MMO Reference: DCO/2022/00007
Planning Inspectorate Reference: EN010125
Identification Number: 20050160

05 March 2026

Planning Act 2008, RWE Renewables UK Dogger Bank South (West) Ltd and RWE Renewables UK Dogger Bank South (East) Ltd Proposed Dogger Bank South Offshore Wind Farms Order

Department for Energy Security & Net Zero (DESNZ) – Further Information Request – 05 February 2026

Figure: 2.1	Drawing No:	
Co-ordinate system: WGS 1984 UTM Zone 30N	Page Size: A3	Scale: 1:850,000
Project:  Dogger Bank South Offshore Wind Farms	Report:

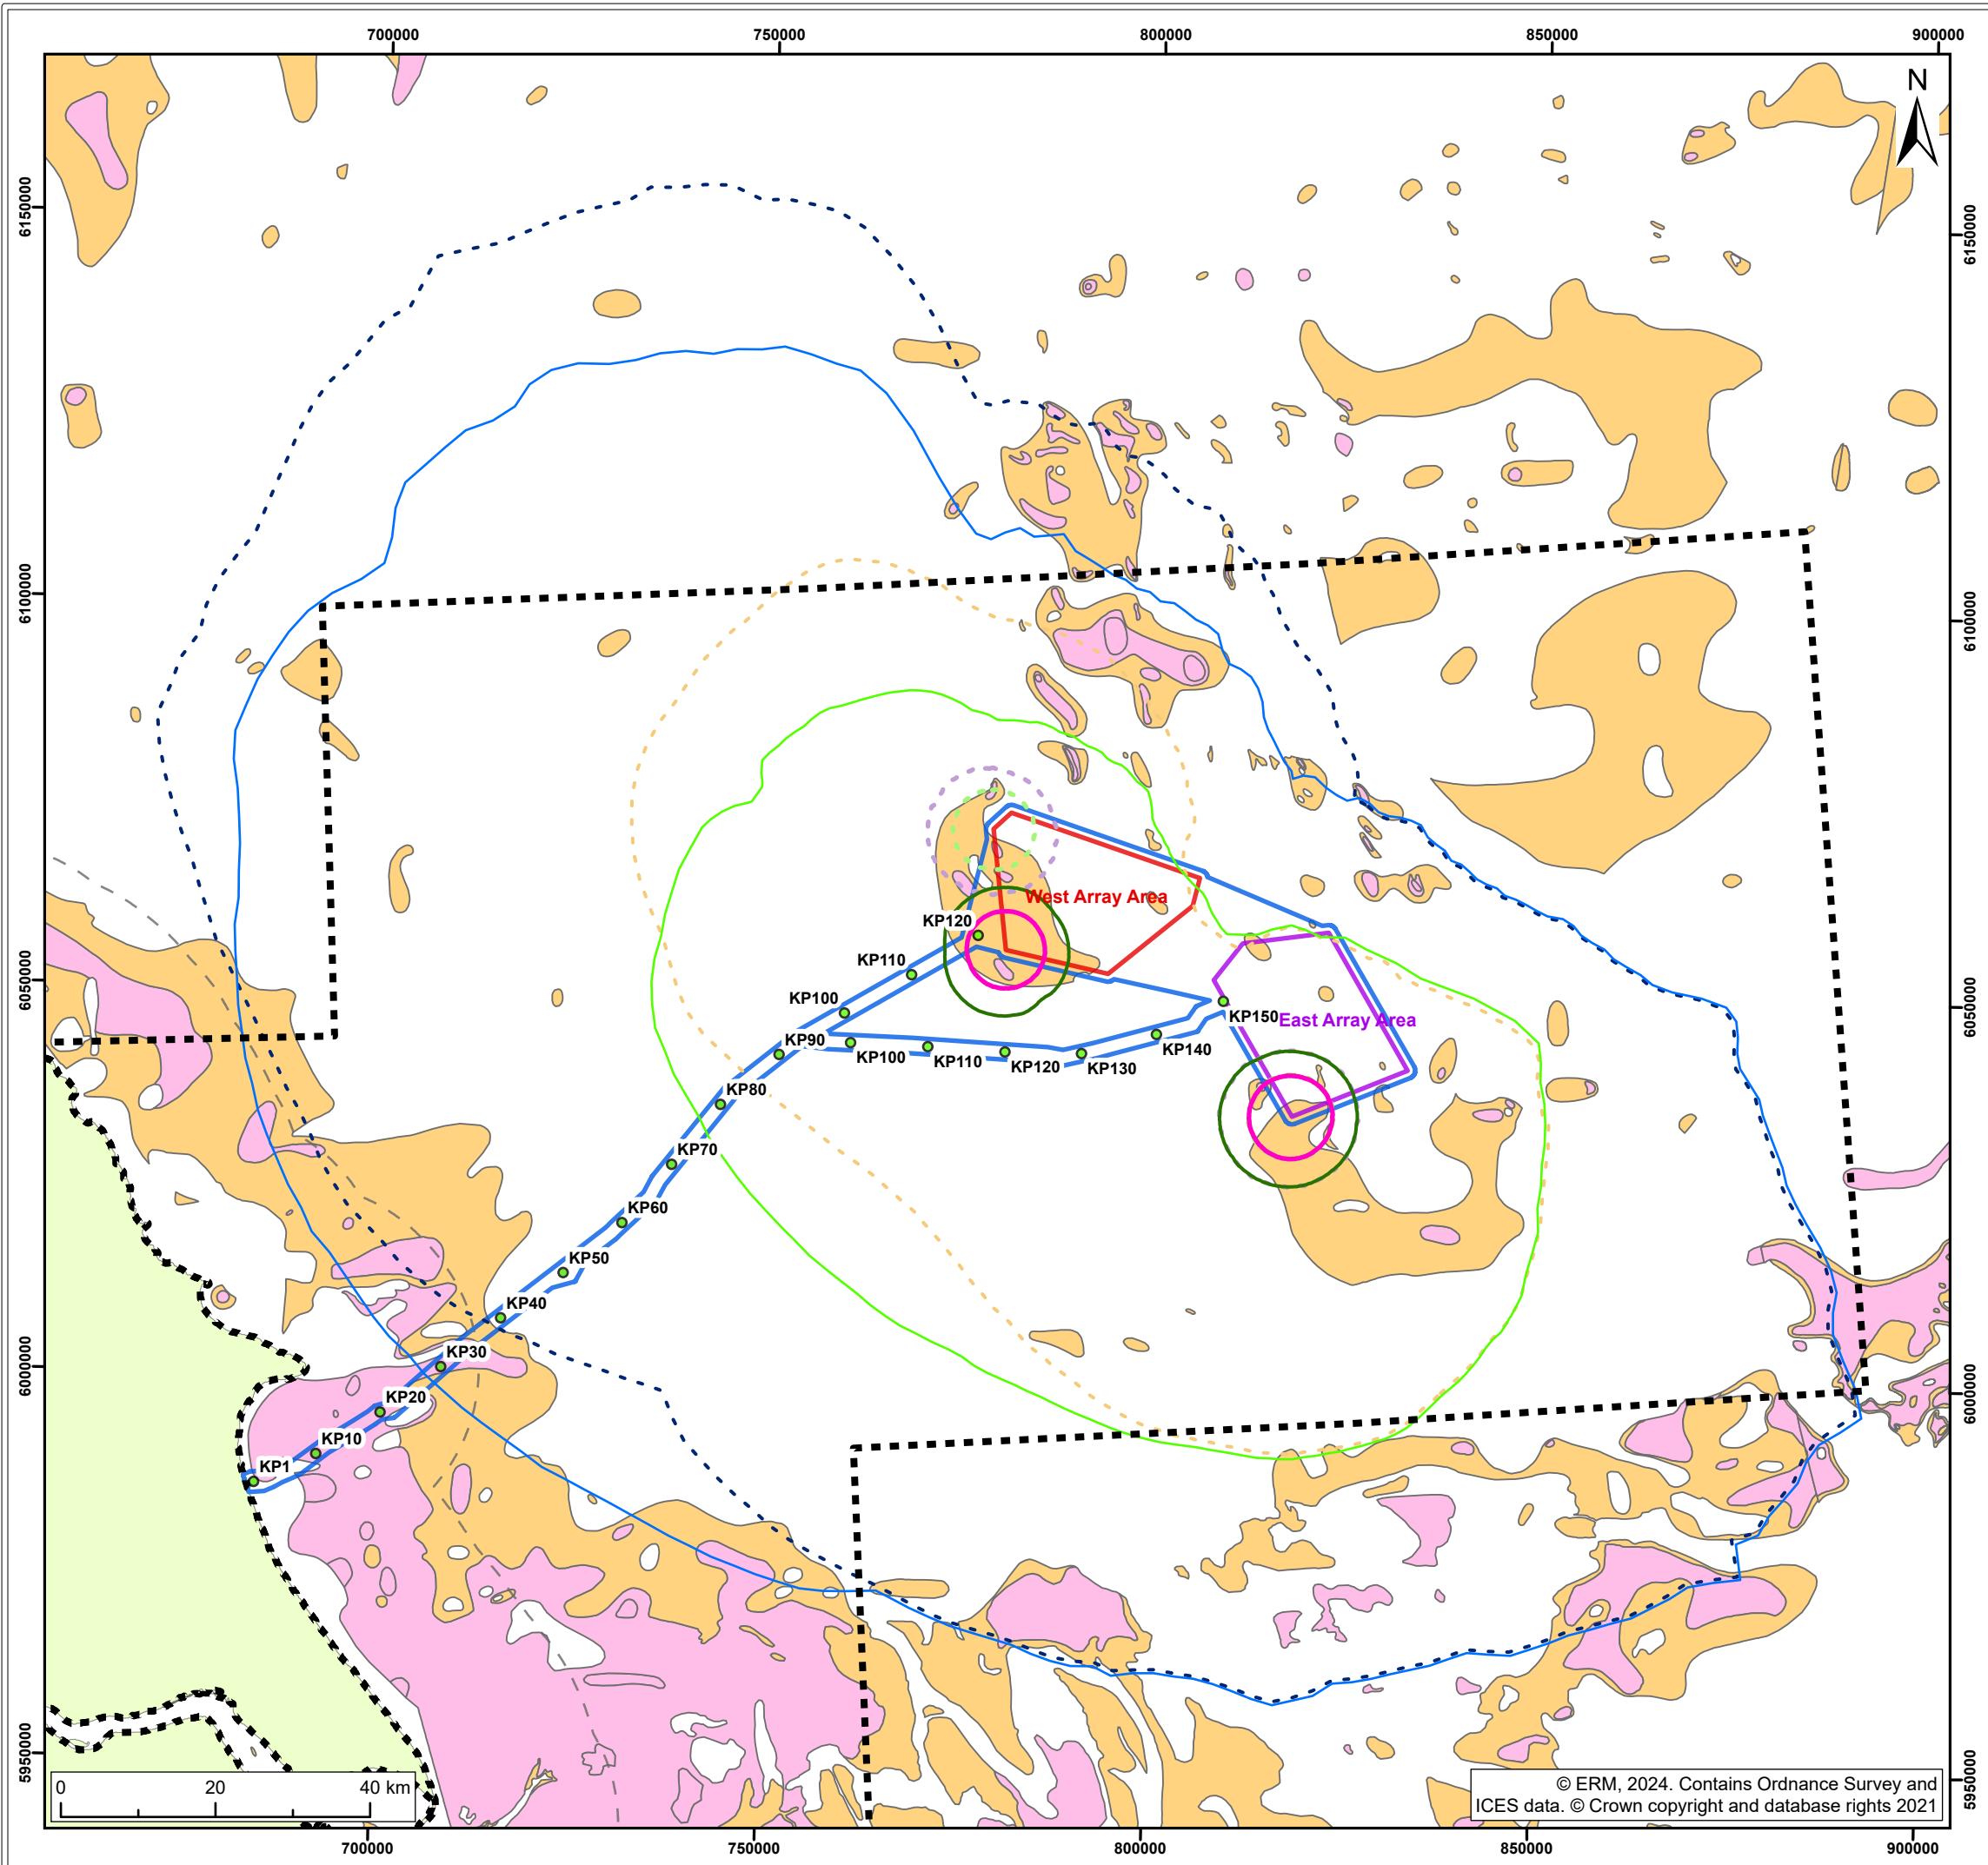
1.2.5	As per Figure 2.1 in REP5-042 (Modelling of underwater noise associated with alternative piling locations to inform potential impacts on Atlantic herring spawning grounds) this shows the worst case scenario with unmitigated piles. Figure 2.2 showed the 'Extent of preferred and marginal potential spawning habitat for Atlantic herring in the vicinity of the Dogger Bank South Offshore Windfarms overlaid with contours associated with revised and original monopiling locations'. The Noise Restriction Boundary line does not sit along the border of the preferred and marginal potential spawning habitat. The use of the terms 'preferred' and 'marginal' only refers to the types of sediment that herring spawning on (e.g. gravel & sandy gravel	The Herring Spawning Noise Restriction Boundary shown on the ' Without Prejudice' Herring Spawning Plan (Revision 2) [REP9-020] has been included where both confidence is identified as 'higher' (<0.05), and where sediment is considered to be either preferred or marginal. In areas where only one or neither of these conditions are met, the likelihood of herring spawning occurring is greatly reduced. The region of medium (peach) confidence indicated is a result of the presence of the International Herring Larvae Survey (IHLS) (general) data layer, which is a polygon surrounding all IHLS sampling locations that have sampled larvae. Whilst this data layer contributes to greater	The MMO has discussed the herring spawning issues with the Applicants post examination in multiple meetings which included our scientific advisors. The most up to date position can be found in Section 3 Fisheries above.

Figure: 2.2	Drawing No:		
Co-ordinate system: WGS 1984 UTM Zone 30N		Page Size: A3	Scale: 1:850,000
Project:  Dogger Bank South Offshore Wind Farms		Report:

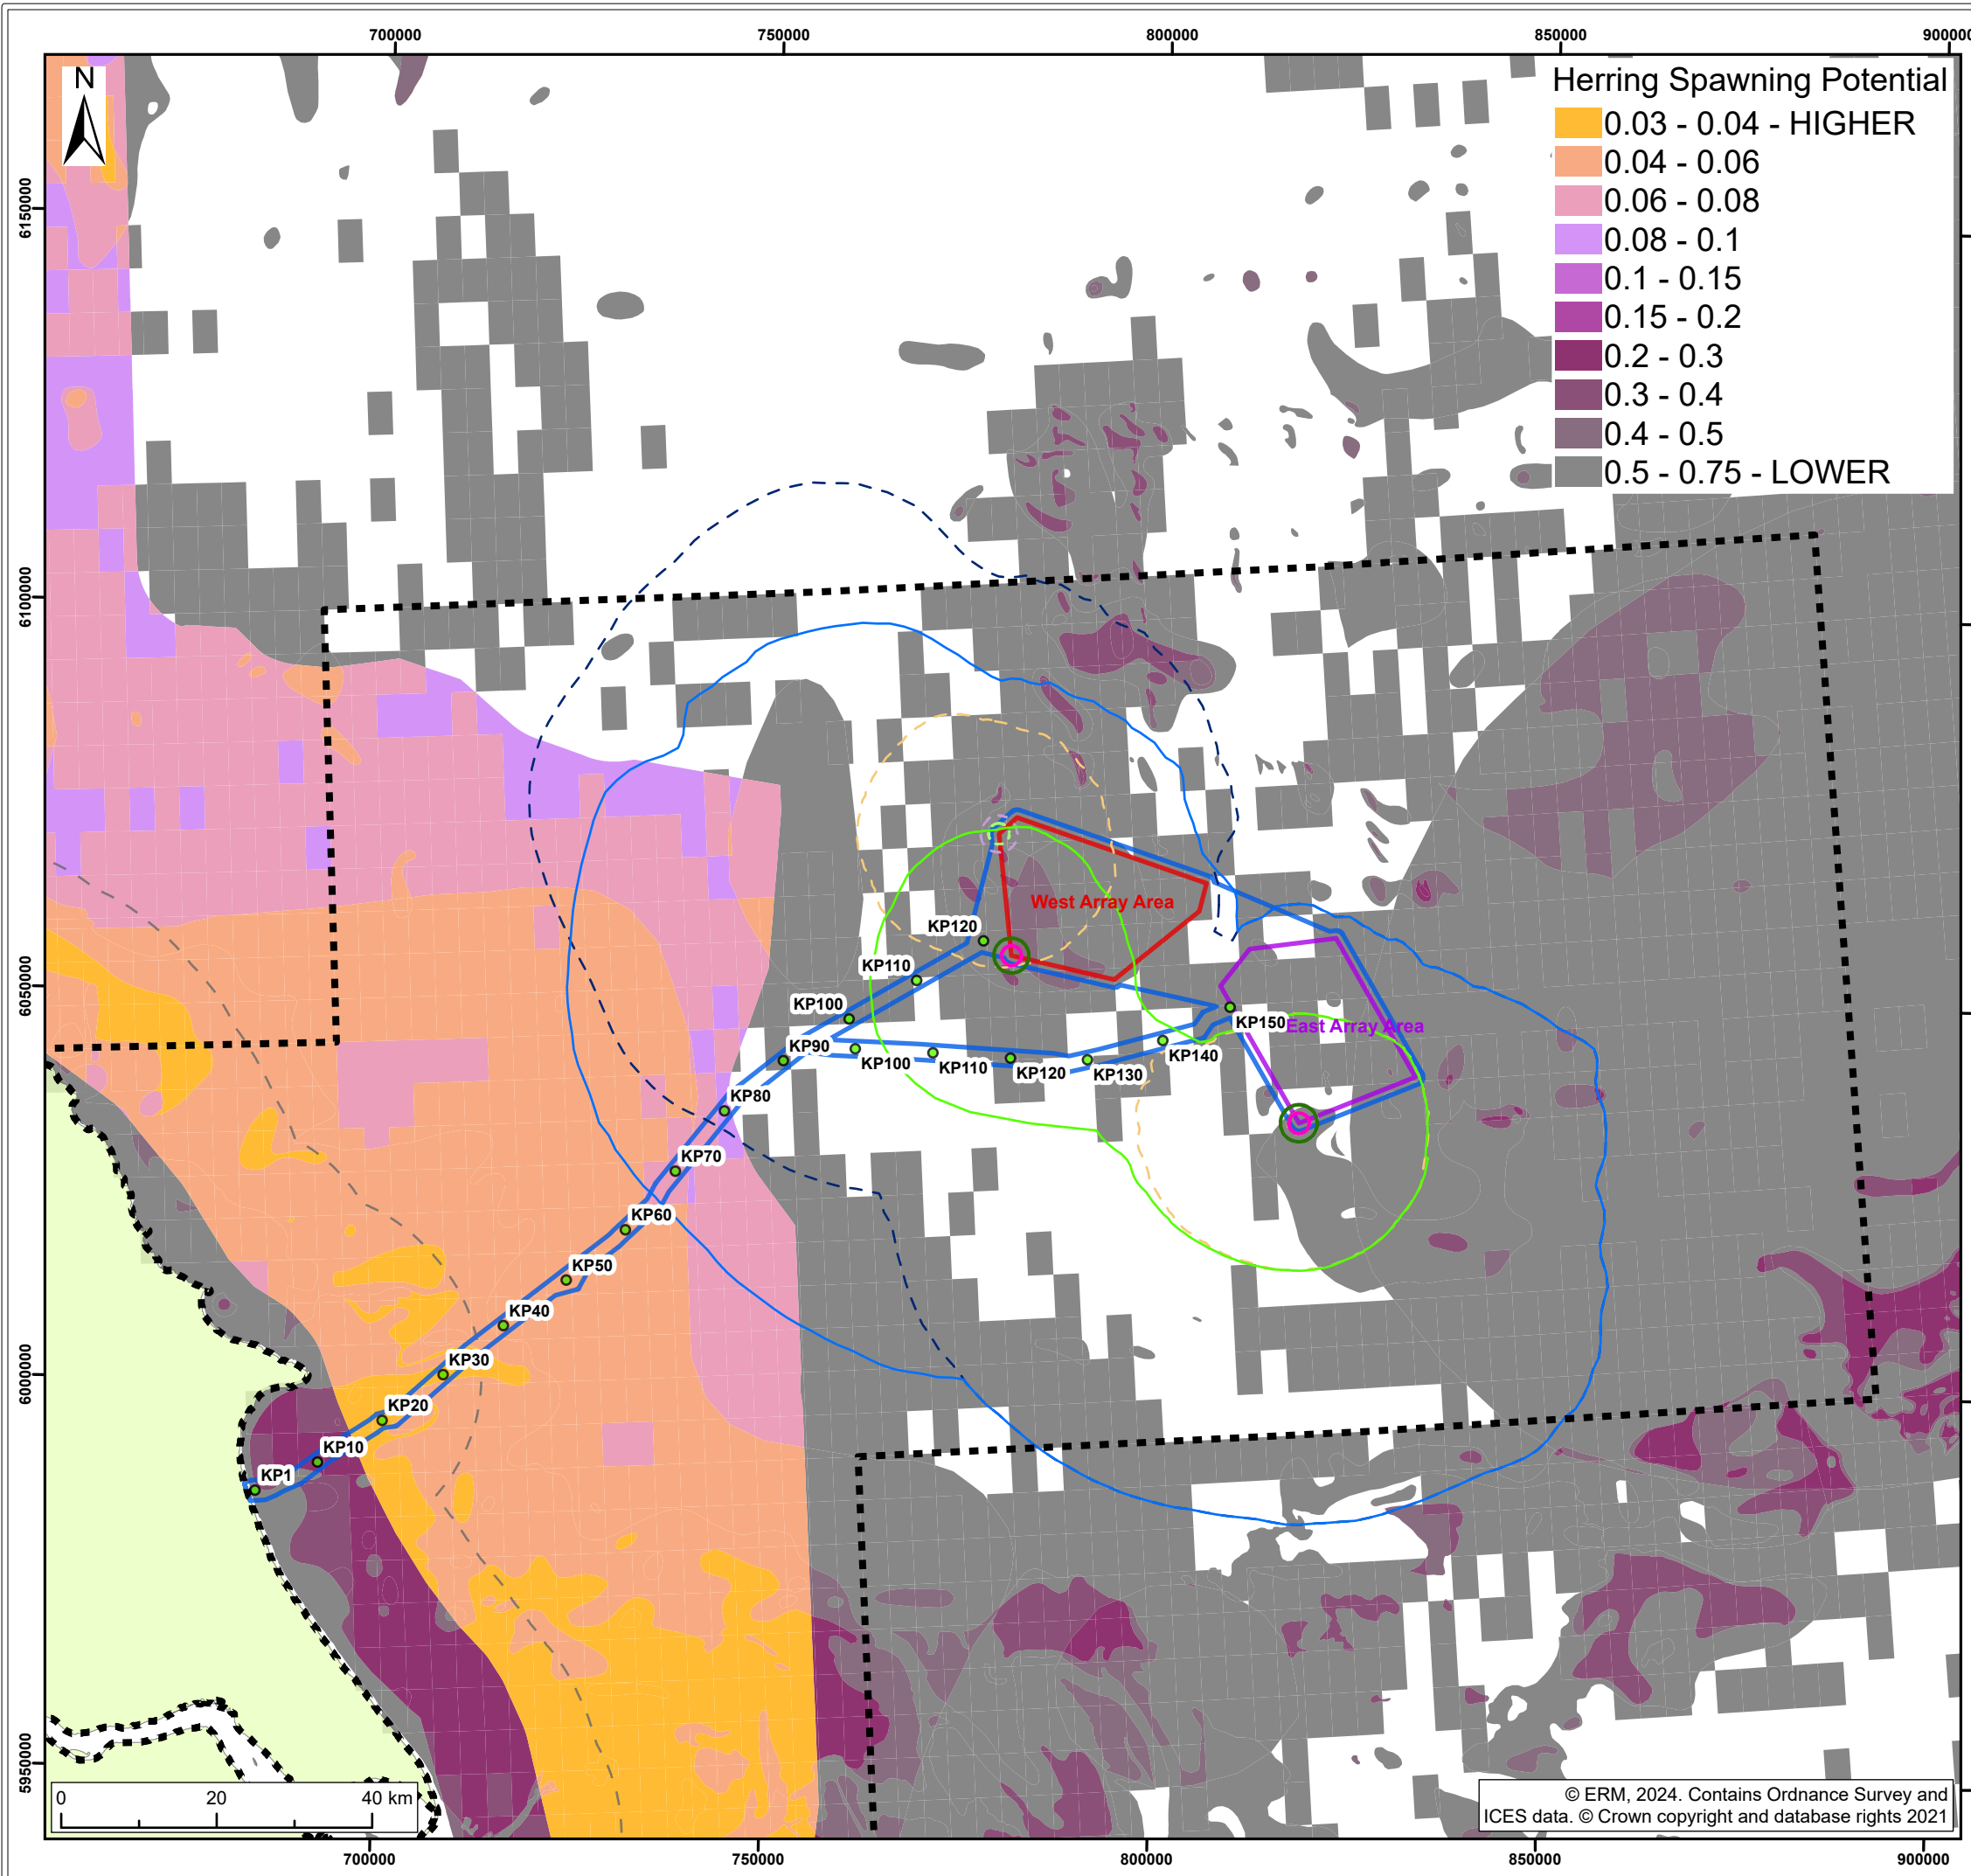
<p>= preferred, gravelly sand = marginal). To be clear, the maps are 'heat' maps comprised of several layers of data including IHLS data and sediment (PSA data). Each data layer is associated with a scoring method, and when the scores of each data layer are combined, an overall 'confidence' score can be given. This gives some areas higher or lower scores, which broadly equate to the different 'heat' colours of the map. So, the heat maps show high (red) confidence in spawning near Flamborough Head, and high to medium confidence (peach) for much of the offshore area, with small patches of low (blue) confidence further out.</p> <p>The Herring Spawning plan shows the Herring Spawning Noise Restriction Boundary along the border the habitat identified within Figure 2.2. Effectively the Applicant has drawn a boundary when there is no evidence linking this boundary to the impact pathway for UWN from piling.</p>	<p>overall confidence, it is not considered reasonable to attribute the presence of this data layer to meaningfully increase the likelihood of herring spawning occurring beyond that of the low (blue) confidence regions further offshore. Therefore, the Herring Spawning Noise Restriction Boundary shown on the 'Without Prejudice' Herring Spawning Plan (Revision 2) [REP9-020] has been drawn along what is considered a realistic, evidence led, boundary dividing a distinct region of higher and lower potential for herring spawning. If the precautionary 135dB behaviour threshold contour (based on underwater noise modelling of the final project design), is seaward of the proposed Herring Spawning Noise Restriction Boundary this will result in a minimum distance of 38km between the coast and the 135dB contour, this distance increases rapidly to both the north and south of Flamborough Head.</p> <p>After continued engagement during the ExA's recommendation period, the MMO / Cefas confirmed via email on the 24th September 2025 that they were content with a 38km migratory corridor (shown in Appendix A) at the shortest distance and the location of the Herring Spawning Noise Restriction Boundary. A joint position statement has been developed (The Applicants' and the MMO's Post-Examination Joint Position on the without prejudice herring noise restriction [document reference: 20.6]), with both parties demonstrating their agreement with the revised without prejudice noise restriction condition wording presented within the document.</p>
